# Rezoning Transportation Analysis

Petition Number: 2021-118

Date	Description
09-23-2021	First Review (KP)
11-22-2021	Second Review (KP)

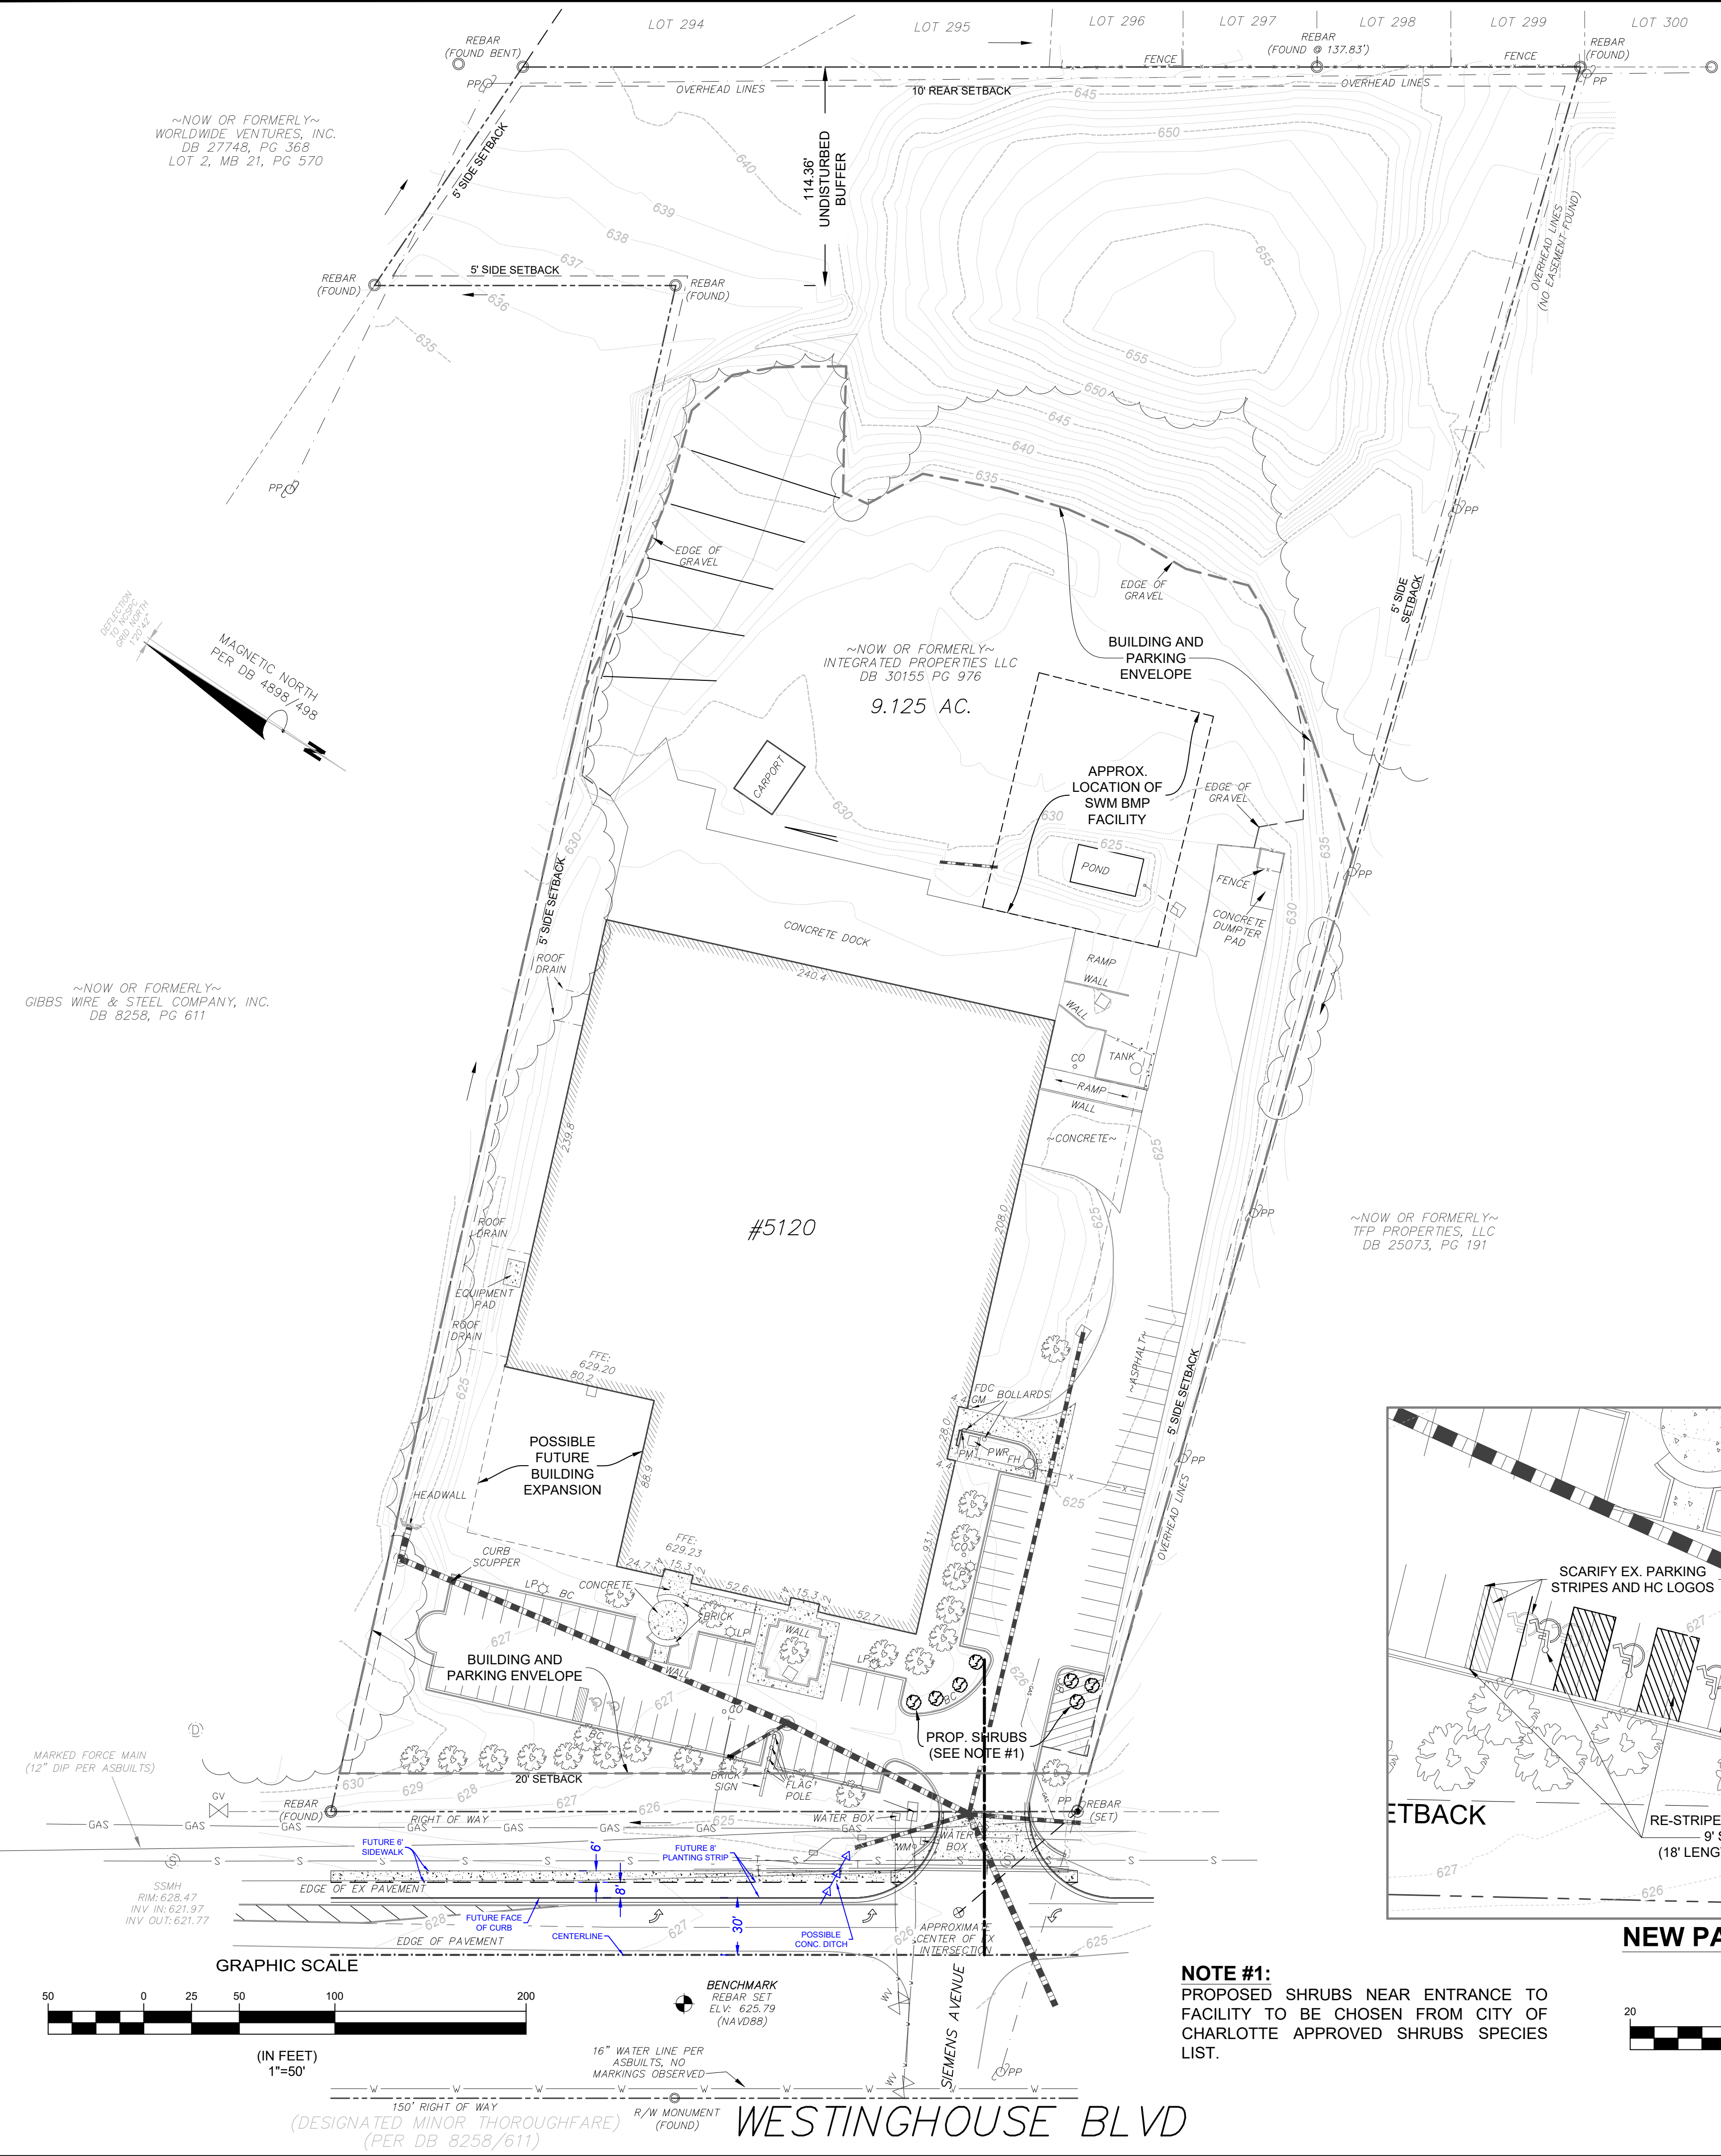
**Update to Comment as a Result of the 11-15-2021 Site Plan:** Revise the site plan by labeling and dimension the curb line from the centerline to back-of-curb.

**Update to Comment as a Result of the 11-15-2021 Site Plan:** Revise the site plan by labeling the sidewalk and planting strip as "proposed".

9. **New Comment as a Result of the 11-15-2021 Site Plan: Revise the site plan to ensure all future and proposed infrastructure, and all linework, is correctly oriented from the existing centerline of Westinghouse Boulevard.**

**10. New Comment as a Result of the 11-15-2021 Site Plan: Review and revise the verbiage of conditional note 4.d for accuracy.**
